COMMENT RESPONSE LETTER

To: Albuquerque Water Utility Authority
From: RESPEC
Date: June 14, 2024
RE: Application For: SI-2024-00547 – EPC site plan sign-off

UTILITY PLAN COMMENT RESPONSES

Below are David G. Gutierrez with Albuquerque Water Utility Authority comments on the utility plan which were provided via email on June 11, 2024. RESPEC's responses are in [blue](#)

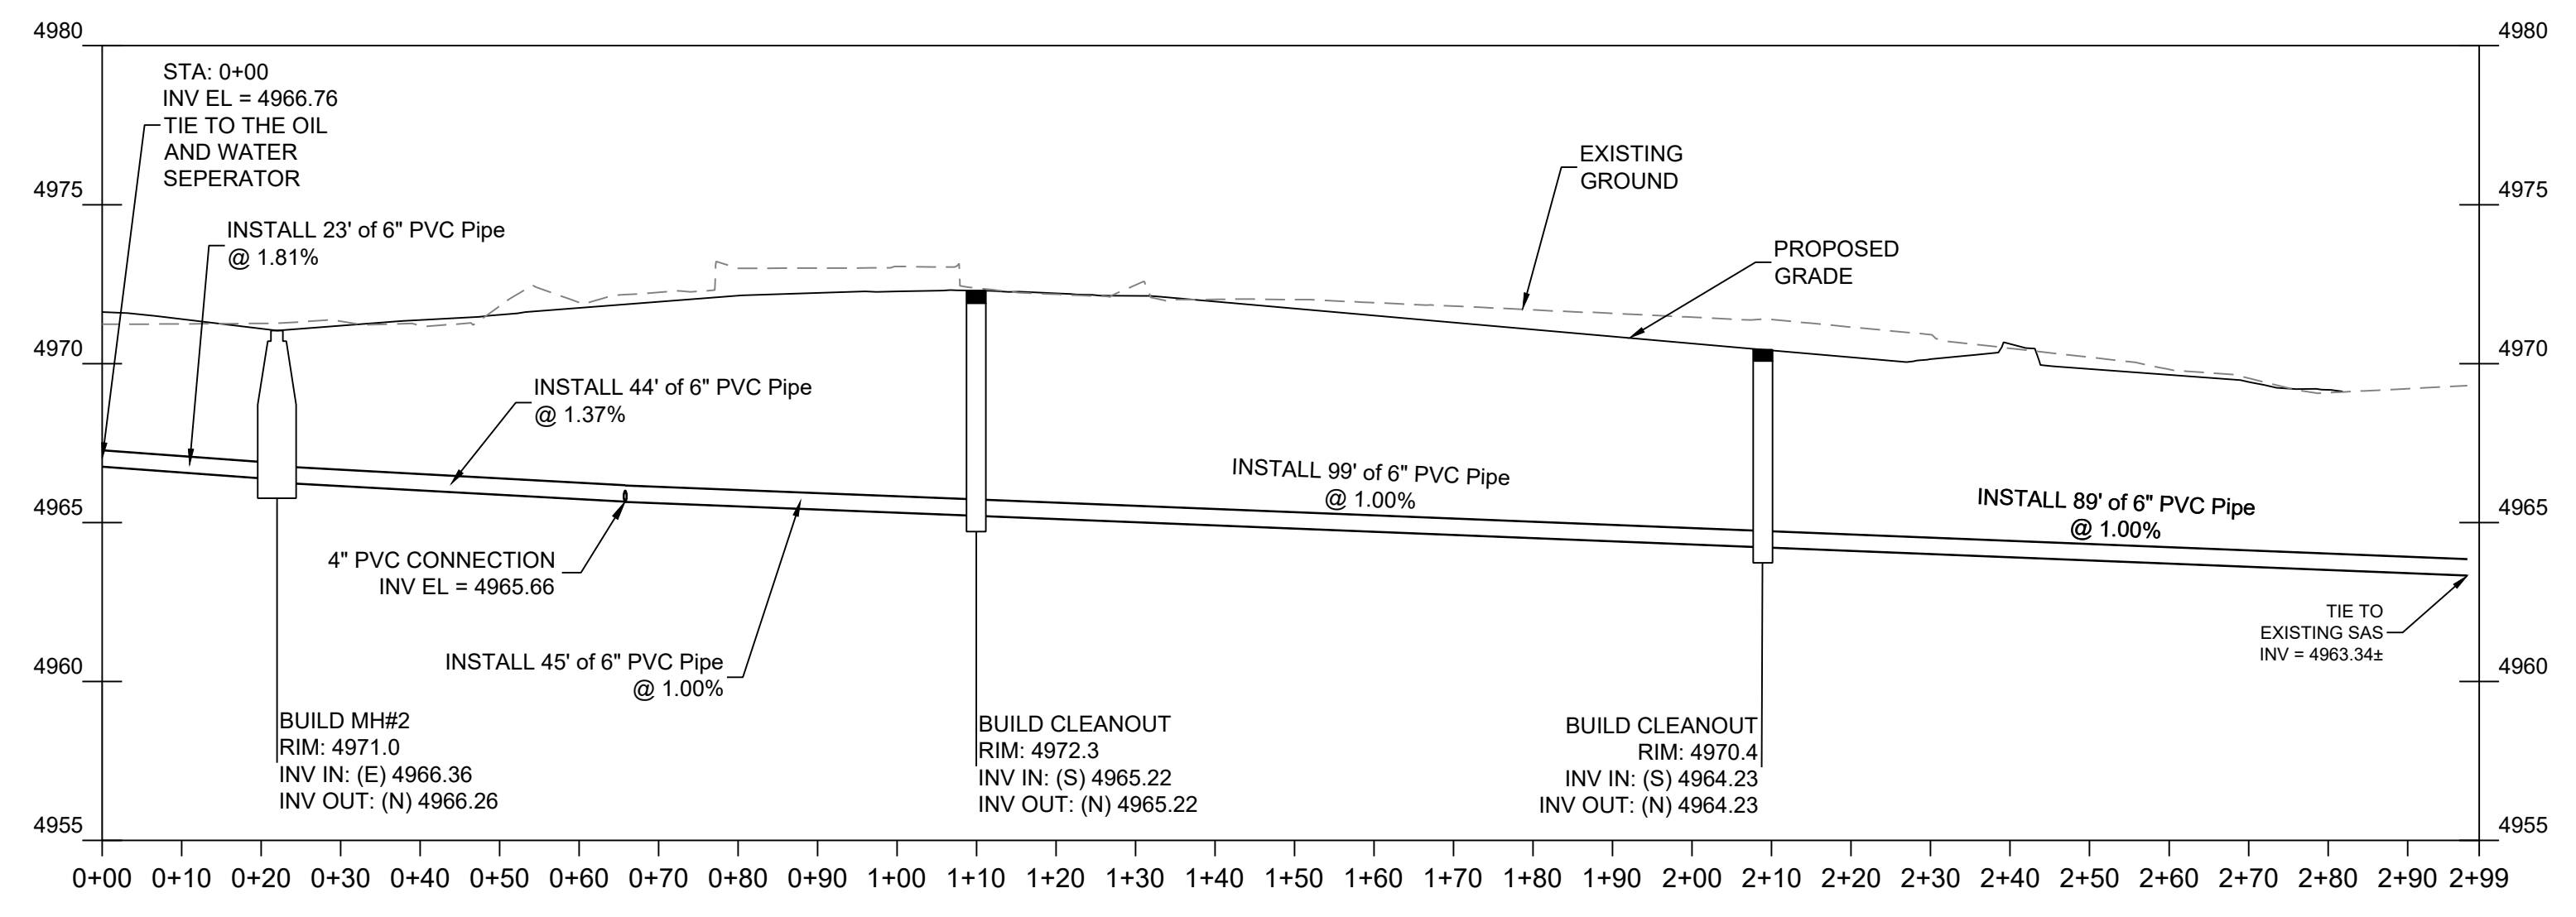
- a. Please add the following notes to the Master Utility Plan. Additionally, please coordinate ahead of time with the
- i. Coordination with Water Authority Cross Connection Section will be required to ensure proper backflow containment is in place prior to release of meter for the site. Contact the Cross Connection Section at 505-289-3454.
 - ii. Coordination with the Water Authority Pre-Treatment Engineer is required to ensure the site complies with Water Authority Sewer Use Ordinance. Contact the Pre-Treatment Engineer at 505-289-3439.

- b. Please appropriately label infrastructure as public or private.
[A note has been added to the utility plan that addresses this.](#)

c. Please figure out if the existing meter is adequate size or not to avoid ambiguity. If needed, please contact our customer service to get someone to meet you out there to determine the size.

- i. Currently the bill size is a size 2 which indicates it is sized for a 1" meter.
- ii. There is also an account showing a size 1 which is a ¾ inch meter.
- iii. Please research and determine what will happen with these existing services. Any that are unused will need to be abandoned (shutoff and removed to the corporation stop).

[These notes have been added to the utility plan.](#)

[The existing 1 inch meter located to the north of the site will be removed and replaced with a 1½ inch meter. The existing ¾ inch meter located to the northeast of the site will be reused as an irrigation meter.](#)
